LSC Responses to FourSquare PUDSP CO TIS Report Redline Comments

Foursquare at Sterling Ranch (LSC# S224590)

Figure 2  
Site Plan

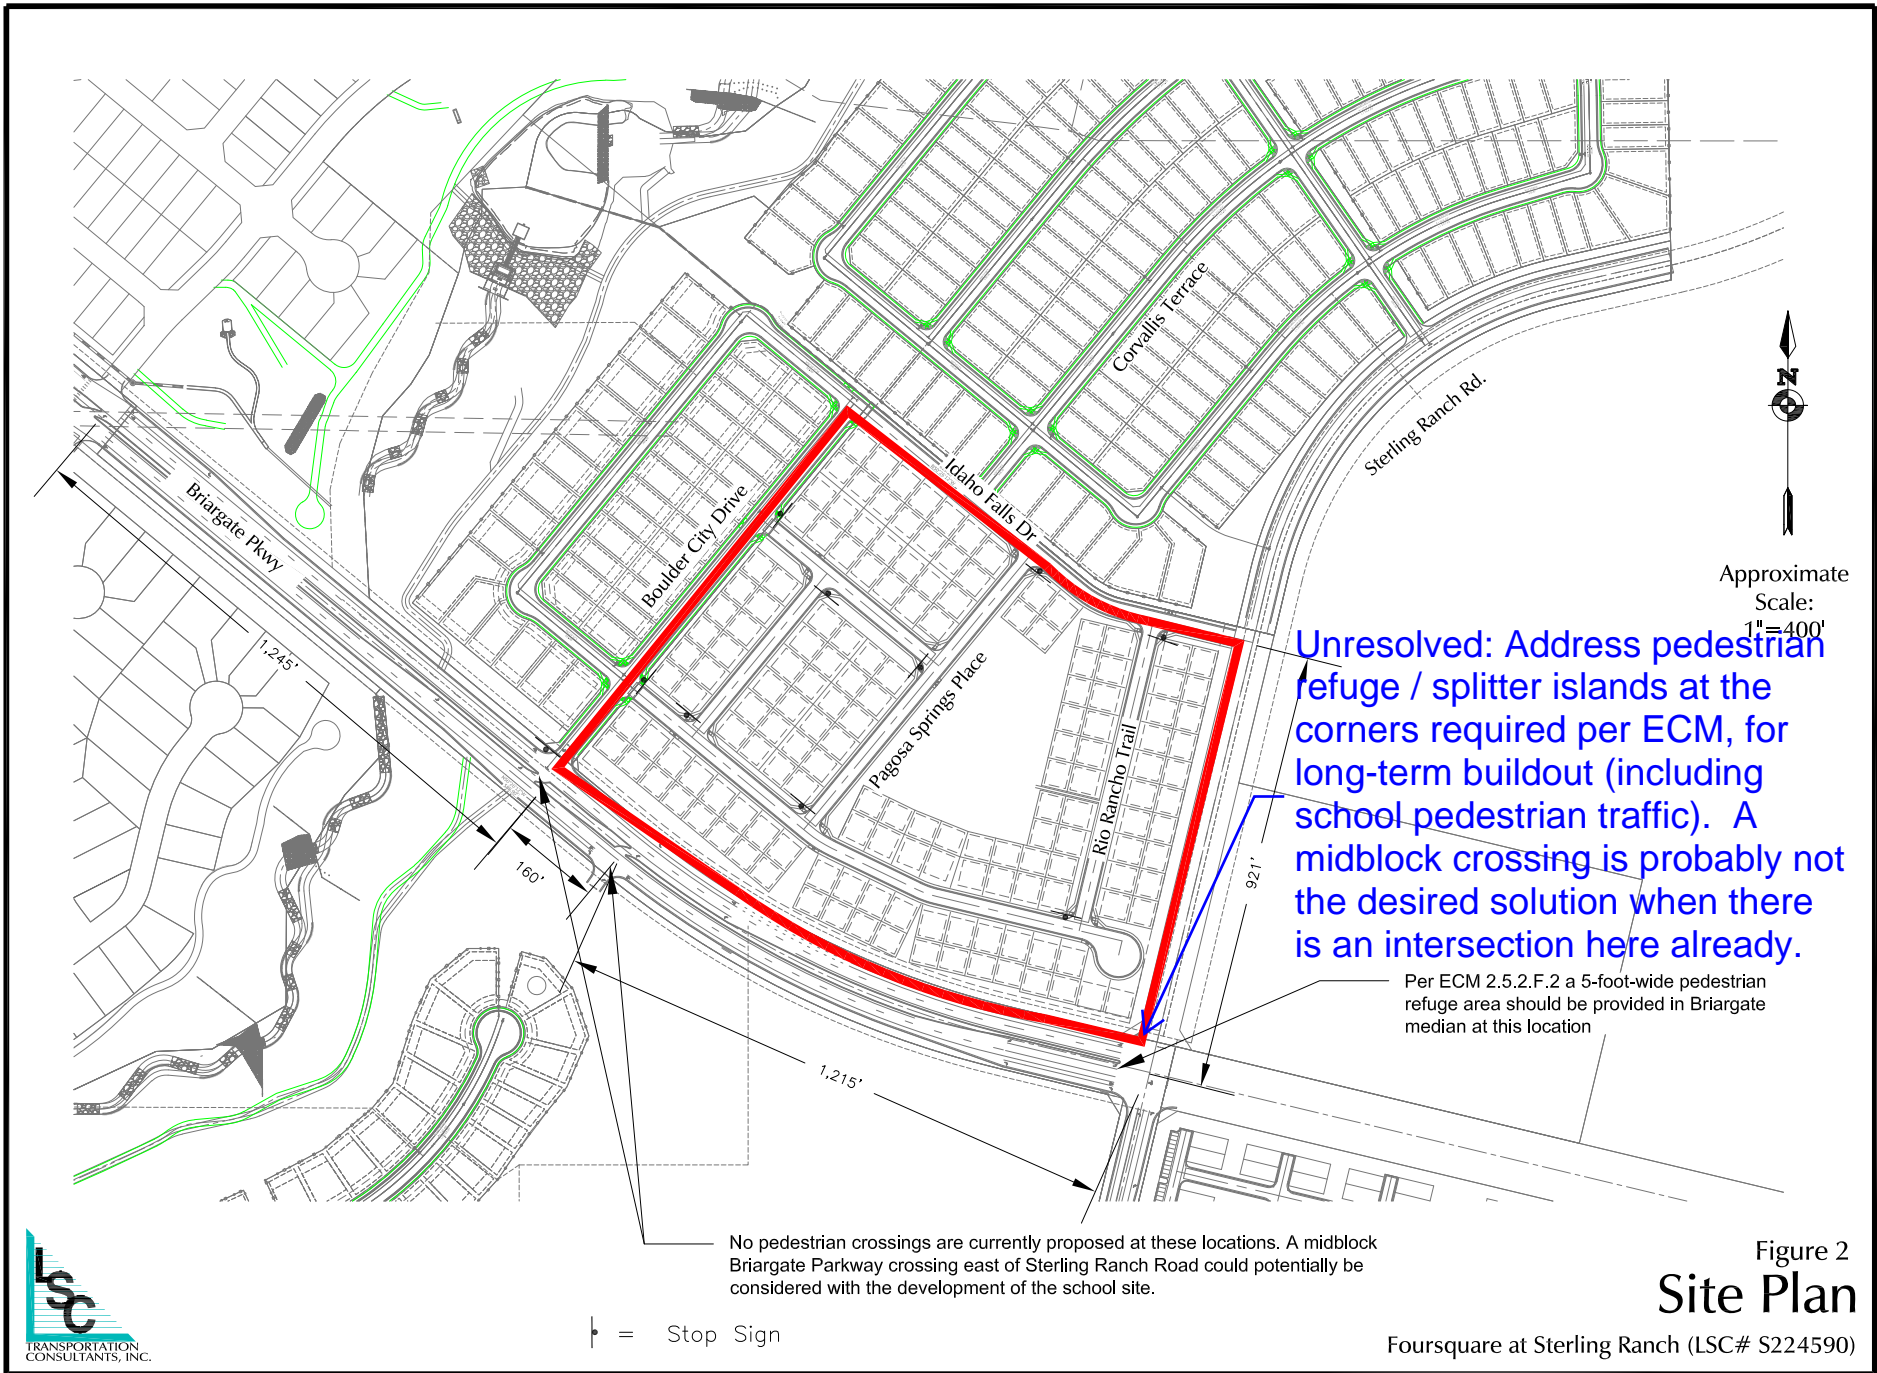
[Unresolved: Address recommendations for pedestrian refuge islands where applicable per ECM 2.5.6.G-J. \(see redlines on Figure 2\)](#)

Unresolved: Address pedestrian refuge / splitter islands at the corners required per ECM, for long-term buildout (including school pedestrian traffic). A midblock crossing is probably not the desired solution when there is an intersection here already.

LSC Response: A note has been added to the text and Figure 2 stating that "The final intersection design will need to meet the criteria for pedestrian safety contained in ECM 2.5.2.F.2 and ECM 2.5.6.G-J. It is our understanding that the specific elements of this design are currently under discussion by the applicant and County staff. Once a decision has been reached regarding the planning/design elements, the applicable documents will be revised as necessary (which may include this TIS report)."

LSC Response: A note has been added to the text and Figure 2 stating that "The final intersection design will need to meet the criteria for pedestrian safety contained in ECM 2.5.2.F.2 and ECM 2.5.6.G-J. It is our understanding that the specific elements of this design are currently under discussion by the applicant and County staff. Once a decision has been reached regarding the planning/design elements, the applicable documents will be revised as necessary (which may include this TIS report)."

The note regarding the midblock crossing has been removed.

Figure 4a

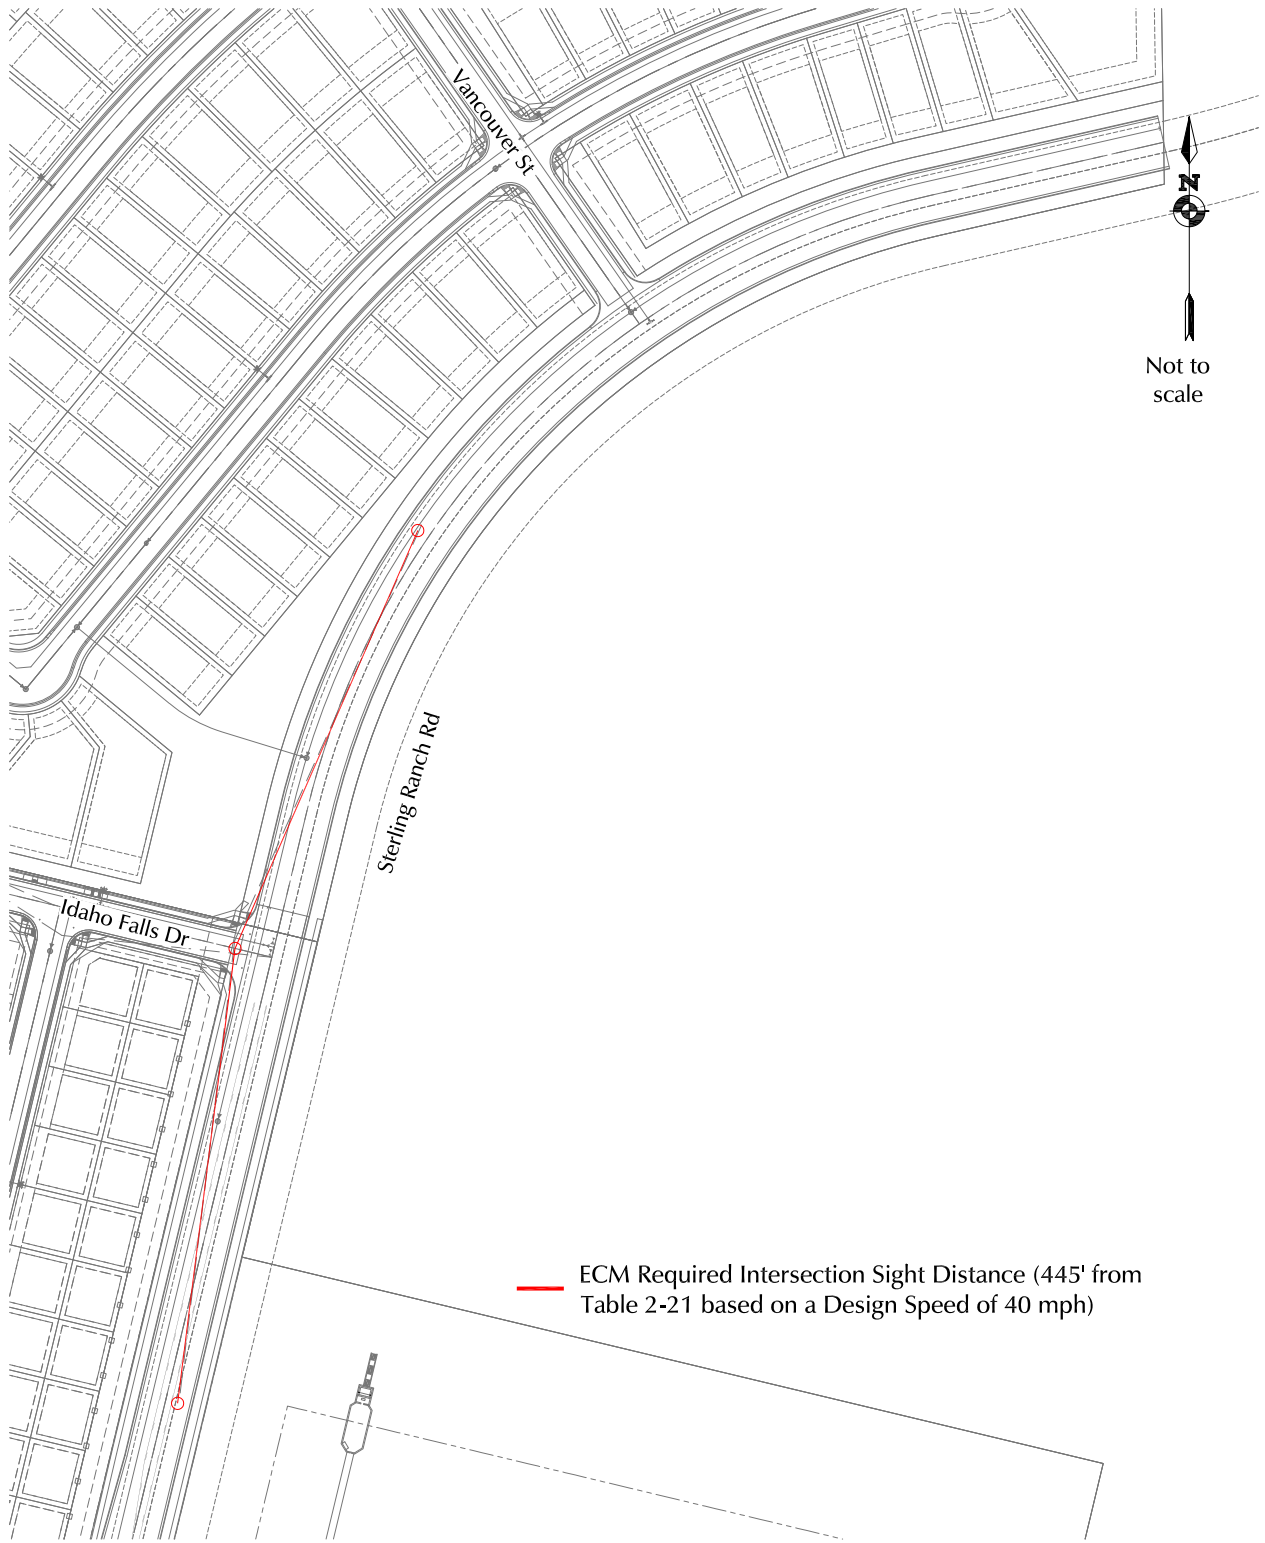
[Unresolved: Address internal sight distances. Some do not meet the 280' minimum \(previous PUDSP redline\)](#)

LSC Response: It is our understanding that the internal sight-distance issues have been resolved on the PUDSP. Please refer to that document.

Traffic studies typically do not present evaluation of all the internal local/local intersections for sight distance, rather they are focused on the more major intersections and street connections to Collectors and Arterial streets.
